Please ask for: Nicola Moore
Email: nicola.moore@arun.gov.uk
Telephone: Ext 37944
Our Ref: A/9/22/CLP
Your Ref:
Date: 24th January 2022

Lawful Development Certificate for a Proposed Use or Development

Development: Lawful development certificate for the proposed conversion of existing attached garage to provide residential accommodation.
Location: The Honey Pot Honey Lane Angmering BN16 4AB

South Elevation

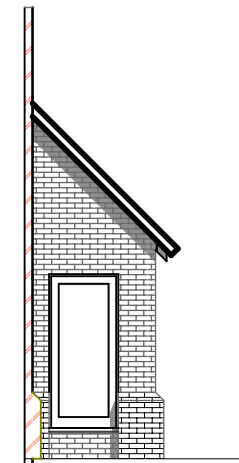
The Proposed Ground Floor includes a door on the South Elevation, but this is not included on the Proposed South Elevation. Please amend accordingly and re submit.
